DECISION DELEGATED TO DEVELOPMENT MANAGER

Application No: H21-0582-20 **Applicant:** Mr & Mrs Wykes
Proposal: Domestic workshop/domestic storage building
Location: 1 Pumping Station Cottages Station Road Tydd Gote
Terminal Date: 14th September 2020

PROPOSED REAR
ELEVATION (NORTH)

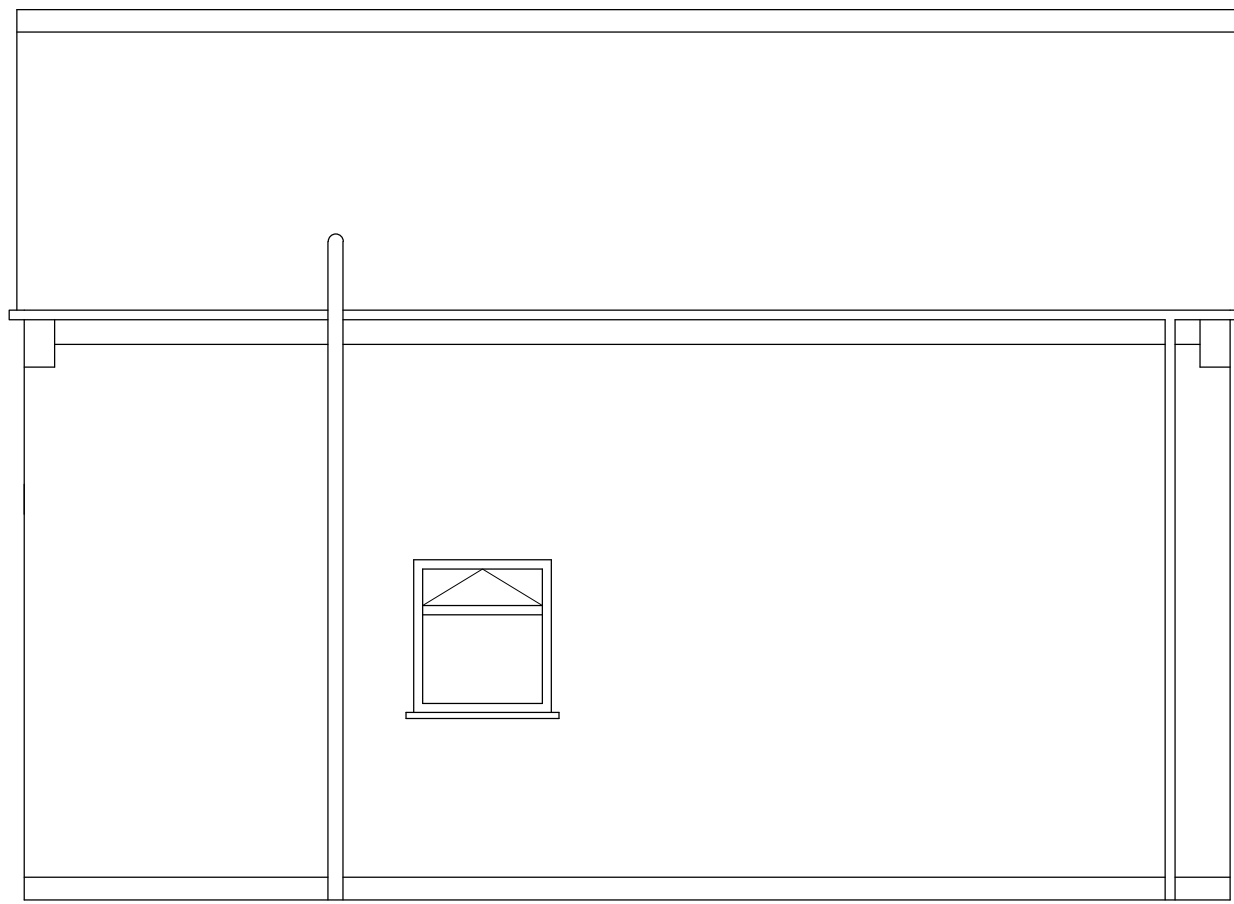
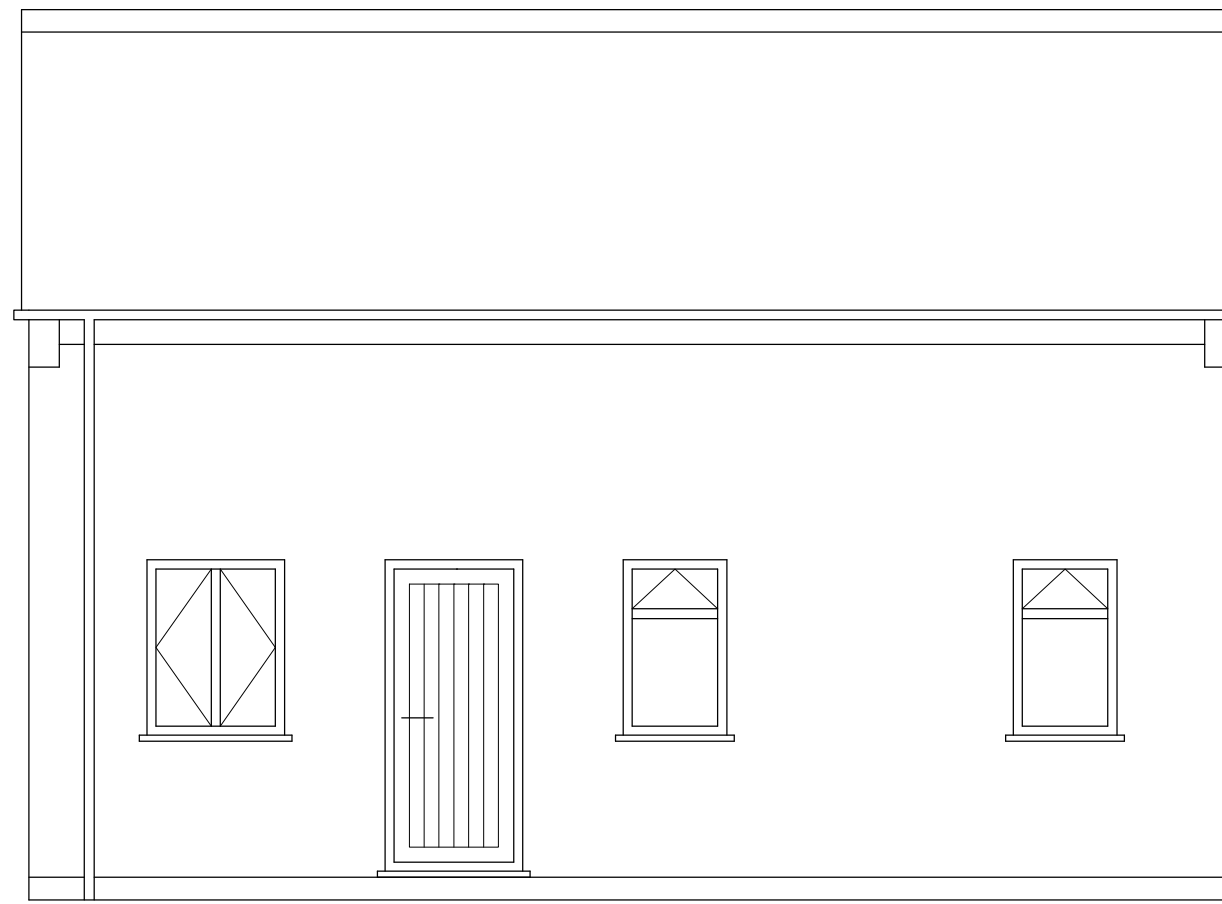
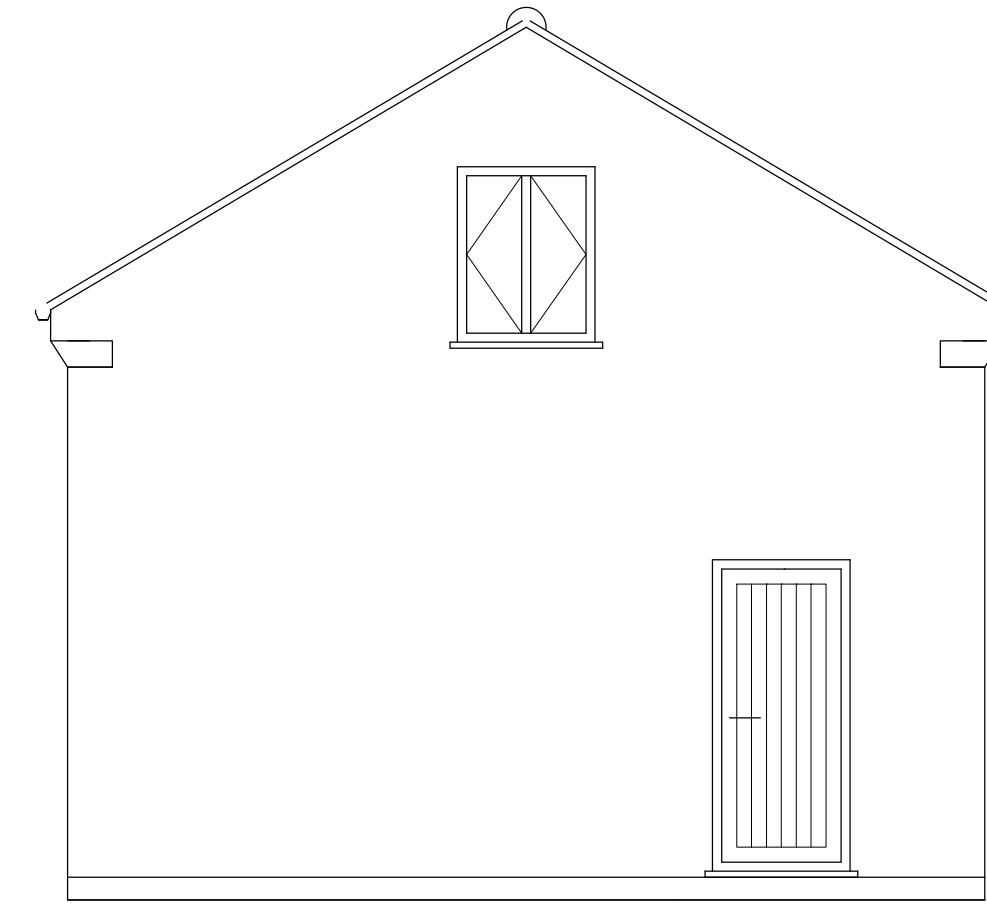
The proposed outbuilding will be nearly 6 metres wide, 8 metres long and 5.90 metres high. The eaves will be roughly 3.50 metres. Having regard to the dimensions of the house, the development will appear subservient with the host property in terms of scale, mass and bulk.

Facing brickwork, roof tiles and rainwater goods are proposed matching the existing materials in the property. The openings will be made of natural treated timber which will provide a more rural character to the development in keeping with the wider location.

The proposed development will be separated 4 metres from the house and aligned with it. Given the apex height will be fairly shorter than the gable pitch of the property, no overbearing nor overshadowing will be created upon the house occupiers.

A Juliette balcony will be opened on the loft space facing the west. The remainder of the garden to that direction is spacious and no other dwelling is adjacent to the plot on that side. No overlooking effect therefore will occur.

BLOCK PLAN
1:200

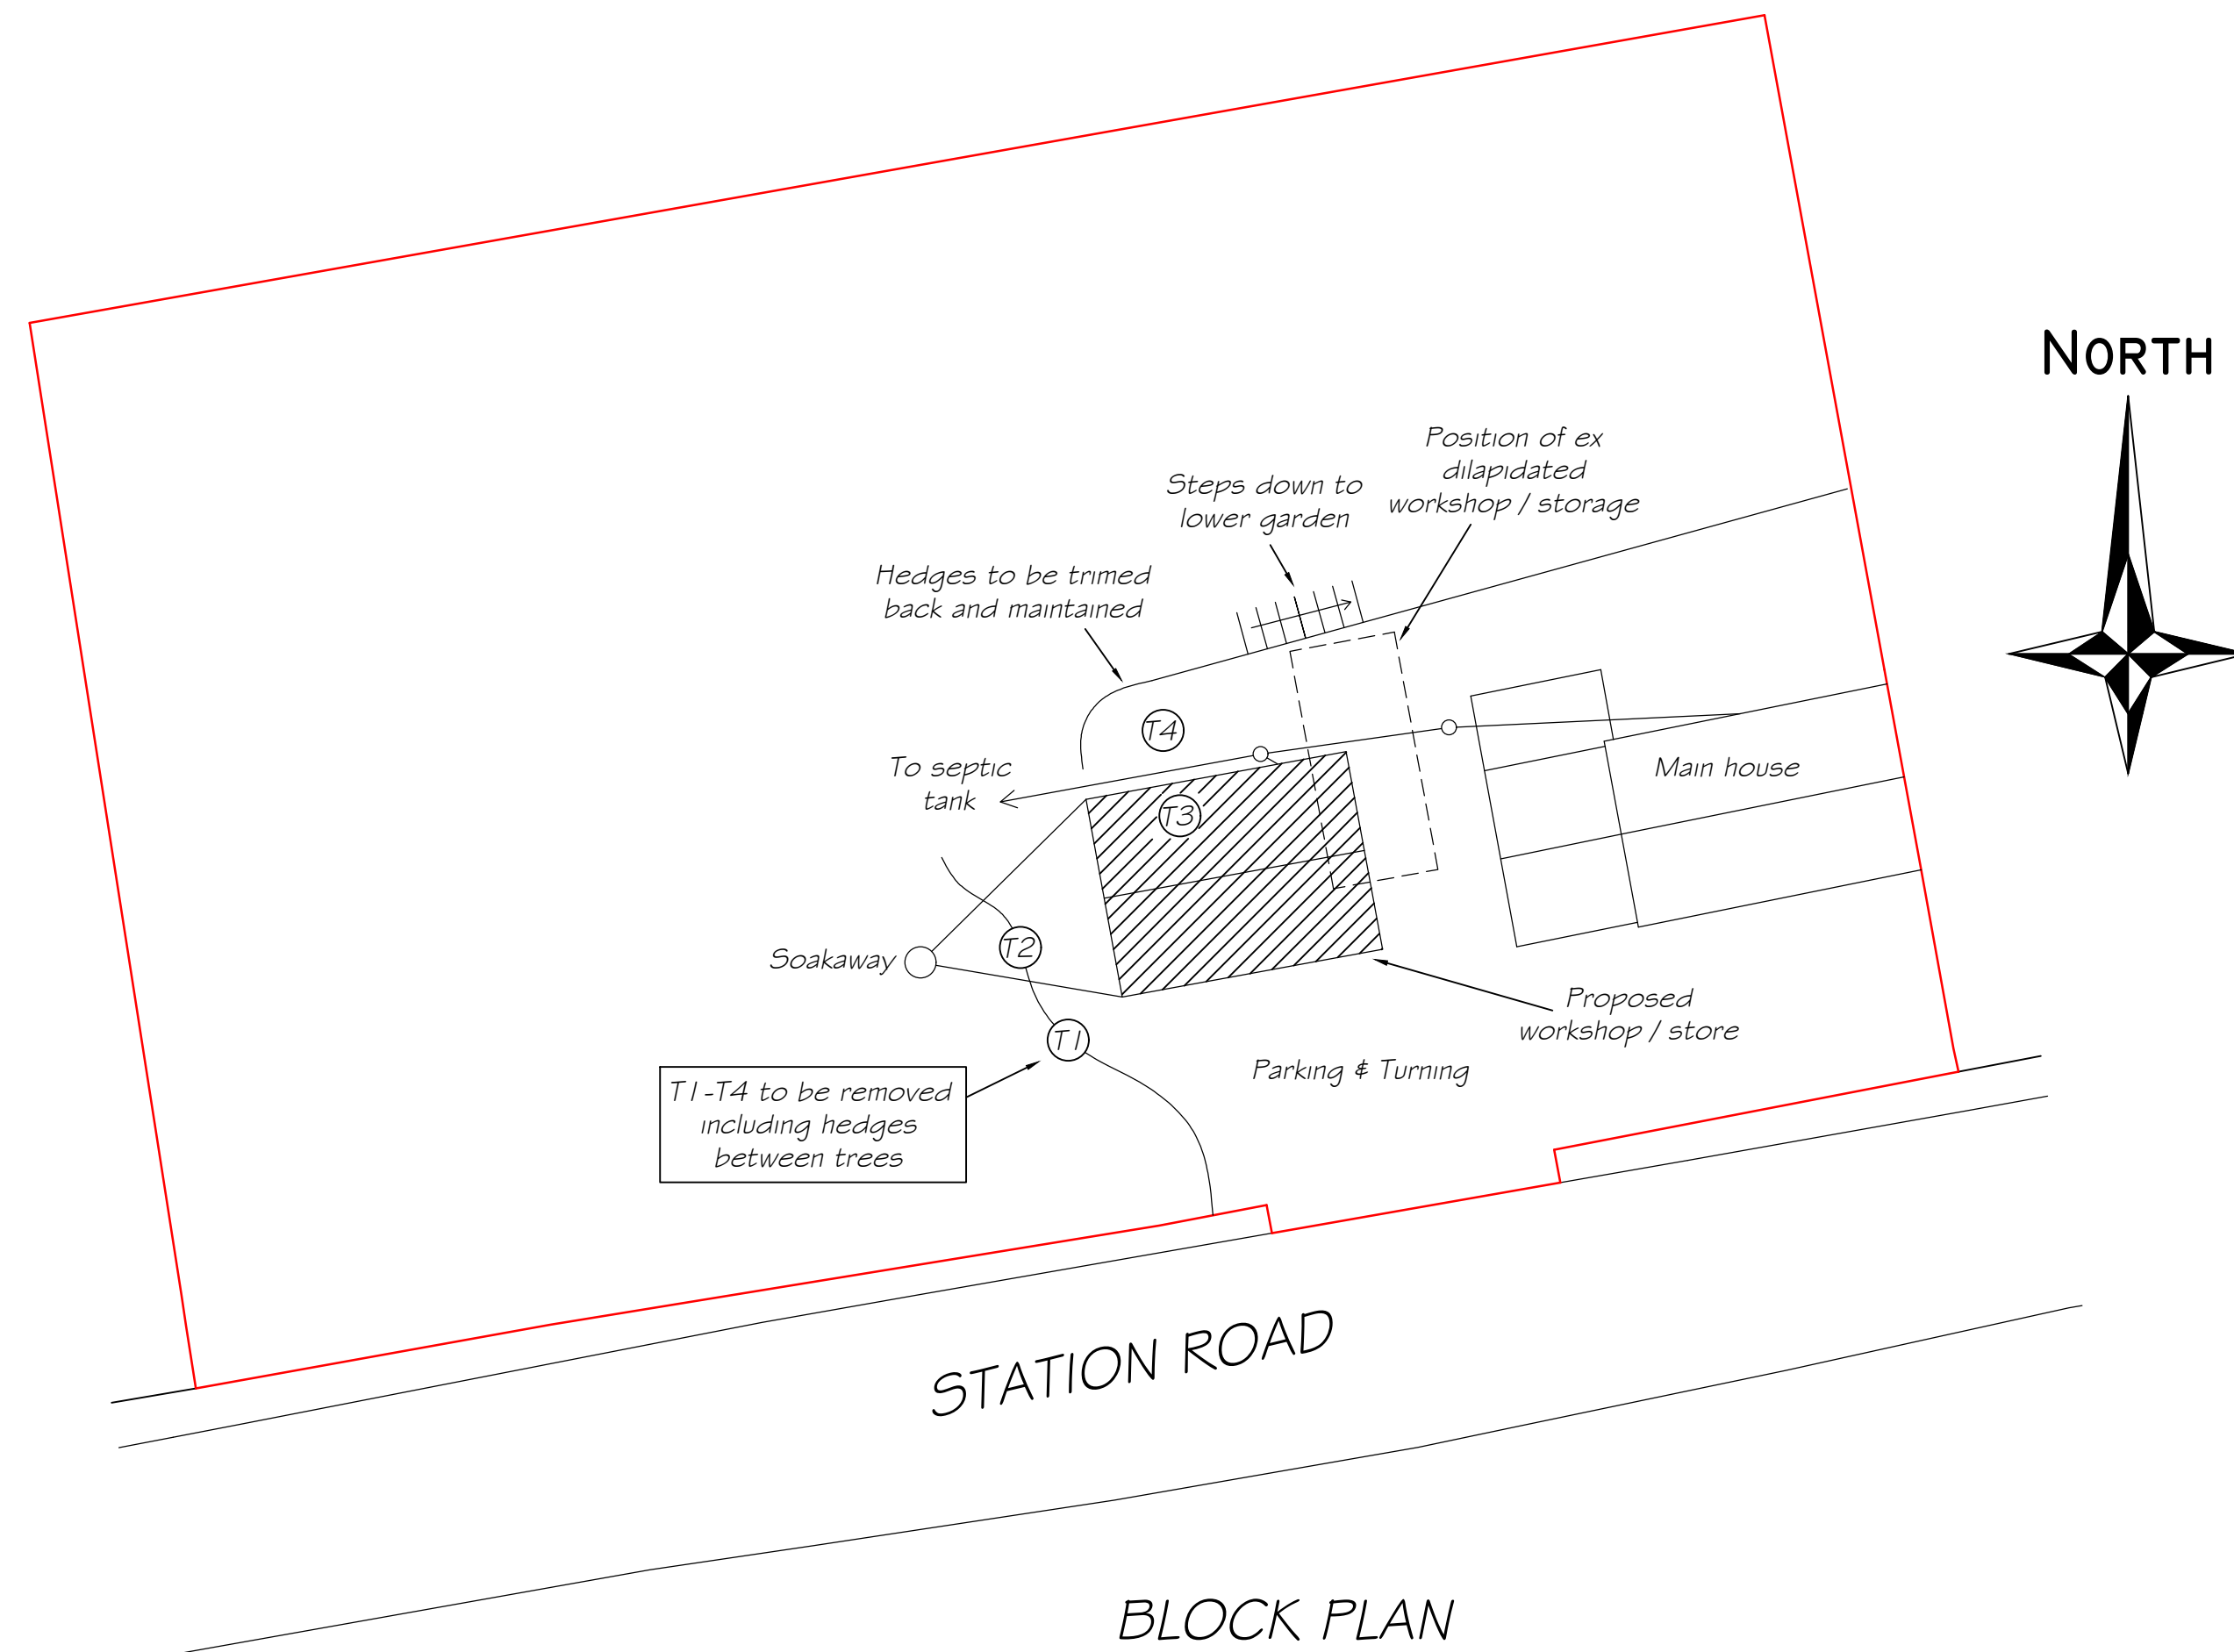
The outbuilding will be set back 4 metres from the property and 7.80 metres from the road. Taking into account its scale and height, the development will be appropriately sit on the site without entering into conflict with other outdoor spaces of the plot (driveway, garden).

A soakaway will be installed in the garden approximately 5.80 metres to the west of the proposed outbuilding. Thus, the development accords with the policy provisions concerned on resilient design to flood risk and overall climate change effects.

The western part of the residential site is heavily populated by trees, hedges and shrubs. In order to accommodate the proposal, four trees near the driveway will be removed and the hedge running to the rear of drive and house will be trimmed. None of the trees is considered of significant relevance as a nature environment asset.

The resulting drive area after carrying out the proposed outbuilding will be approximately 8.85 metres wide and 7.85 metres long which is sufficient to park 3 cars. Therefore, the development accords with Appendix 6 and sufficient car parking is ensured.
